Planning Application Ref: BE/148/20/OUT

Location: Nursery Fields Land to the North of Chalcraft Lane, West Bersted, PO21 5TS

Description of works: Outline application for all matters reserved, with the exception of site access, to provide up to 225 residential units with associated infrastructure, open space and vehicular and pedestrian access. This application affects a Public Right of Way

Tree Officer / Parks and Greenspace Team

TITLE: SITE ACCESS ARRANGEMENT

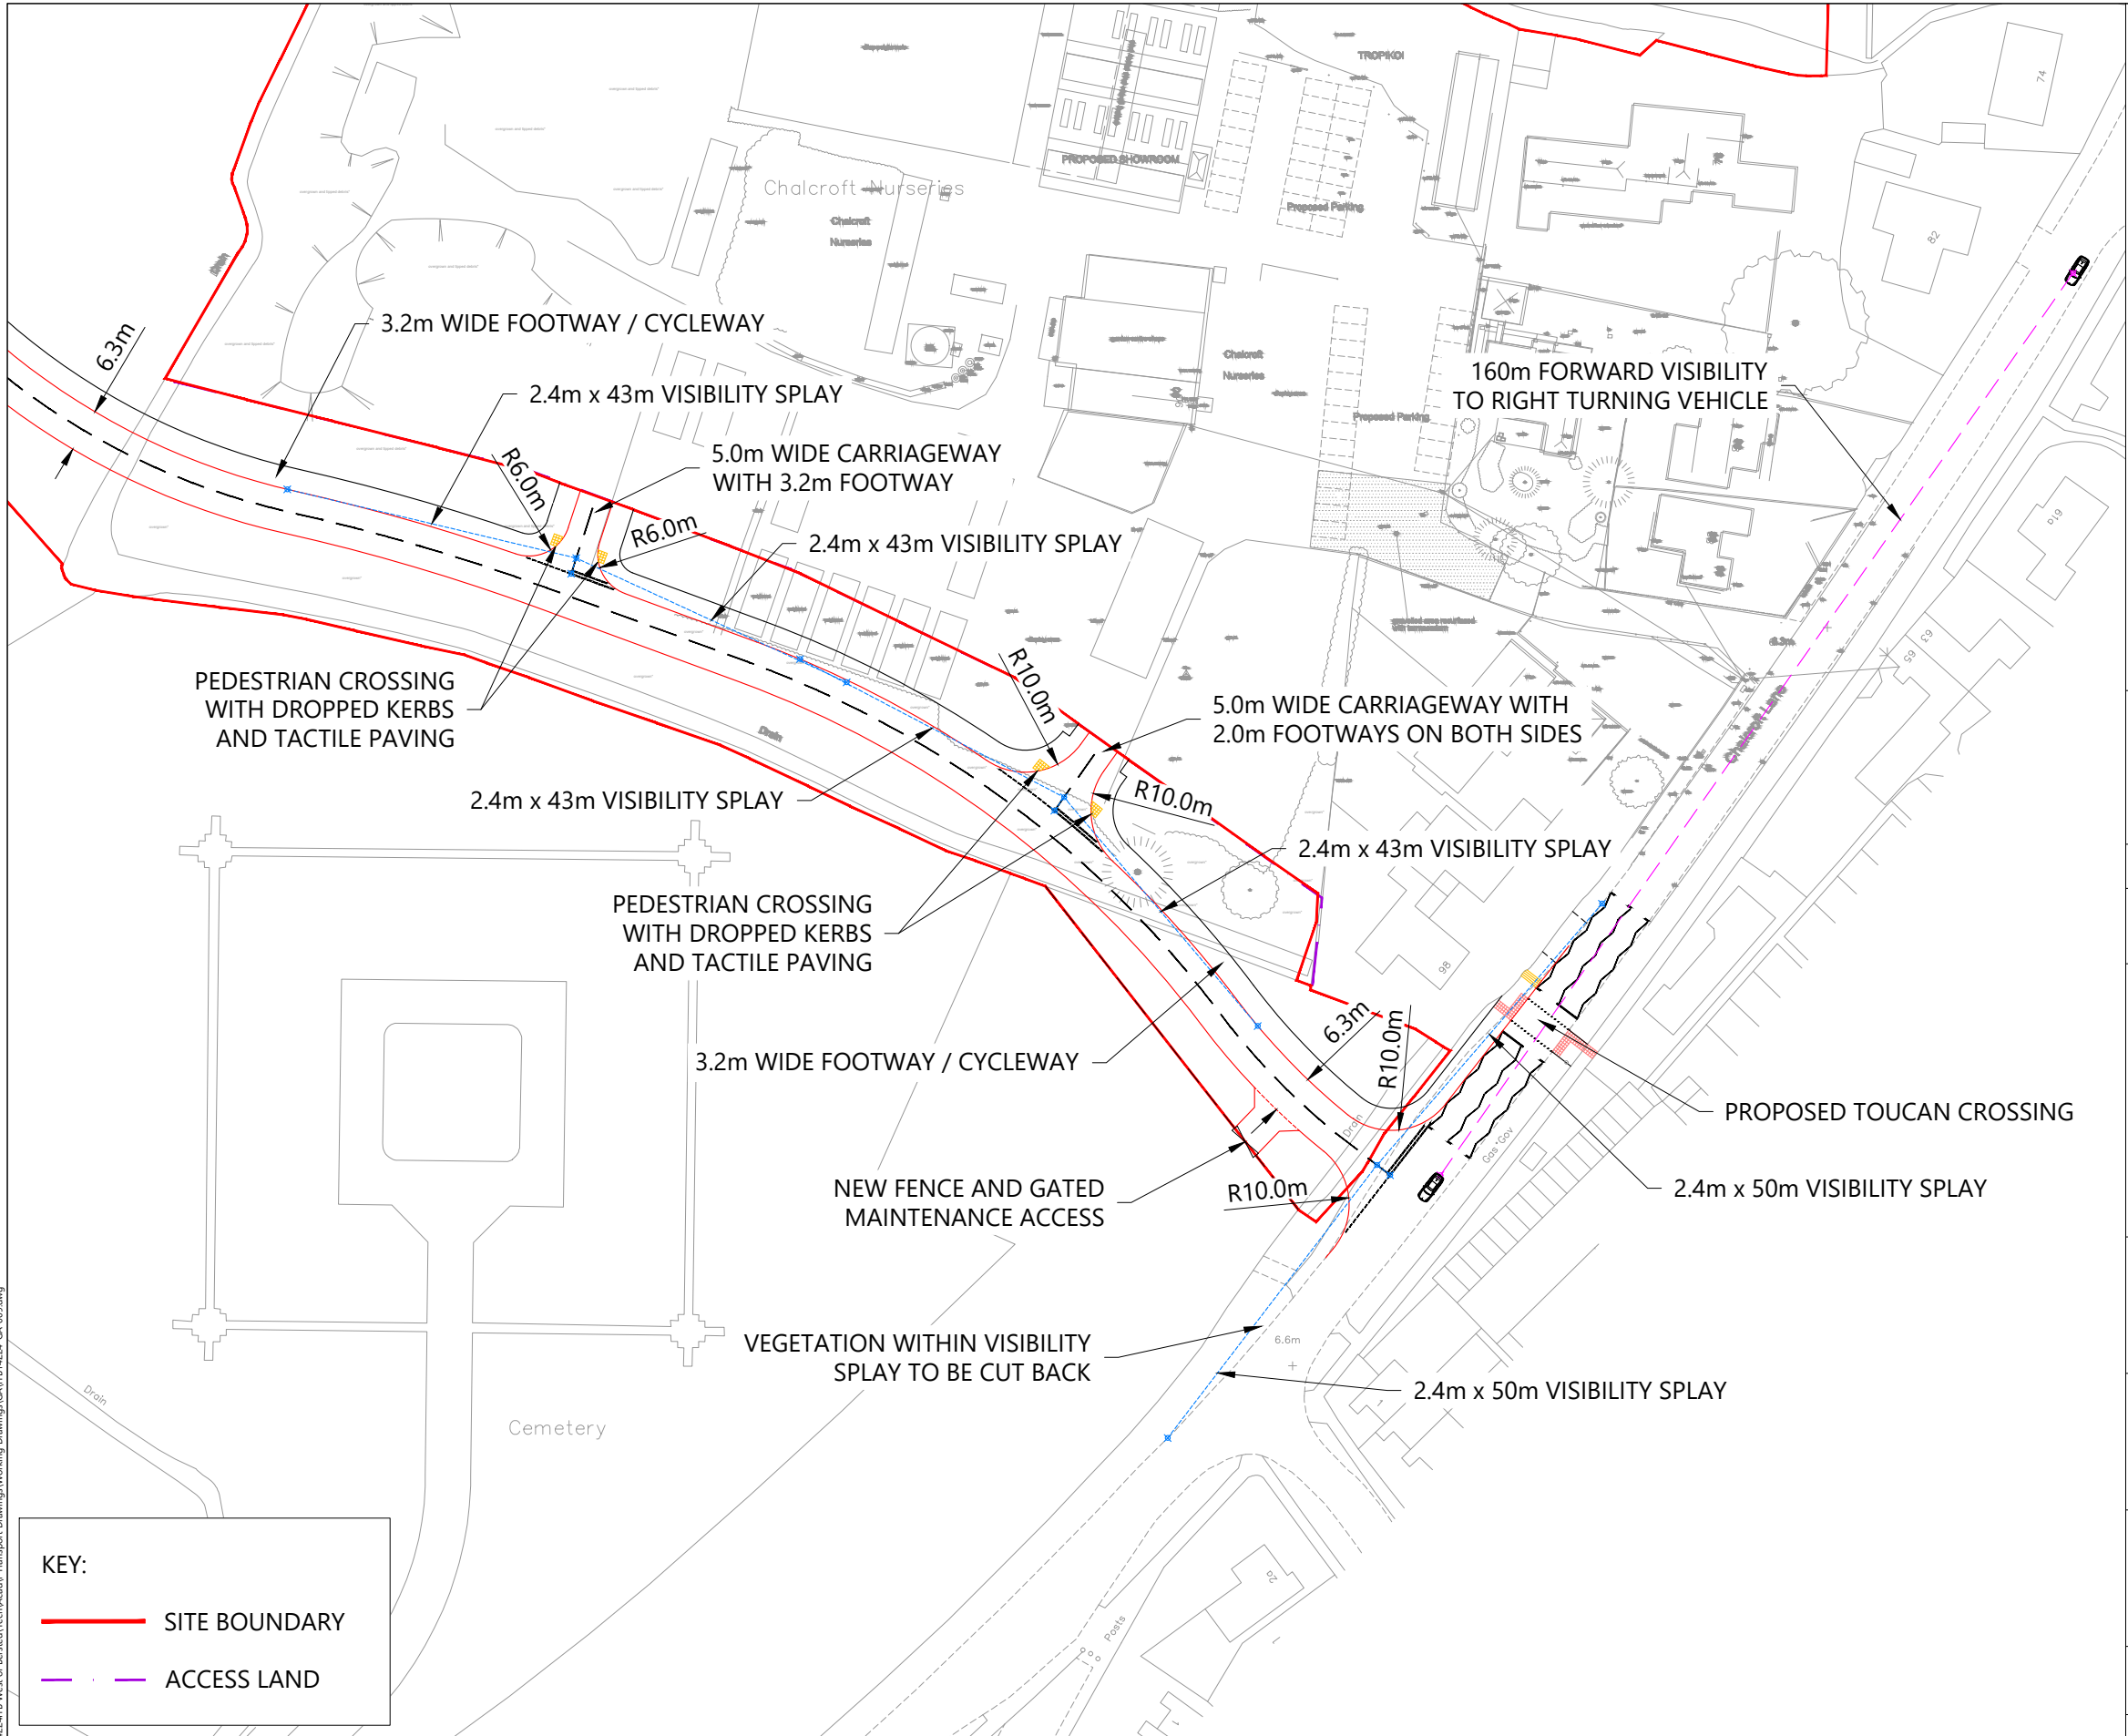
- I see no obvious problem with the proposed location of the main access to site.
- General principles of design layout to be considered
 - Careful consideration should be given to the intended land use beneath existing canopy of established trees and the potential for further tree growth (root and crown extension). With such a large and open site to work with I would expect evolving layout proposals to place great emphasis on eliminating future 'pressure to prune' of retained trees. Furthermore, there would need to be a compelling argument in favour of any Root Protection Area incursion as this site clearly lends itself to a harmonious design that avoids any direct interference with established trees of current and future landscape value. This is especially relevant where there are trees of high amenity, landscape and potential heritage value (which qualify for statutory protection), as is the case here.
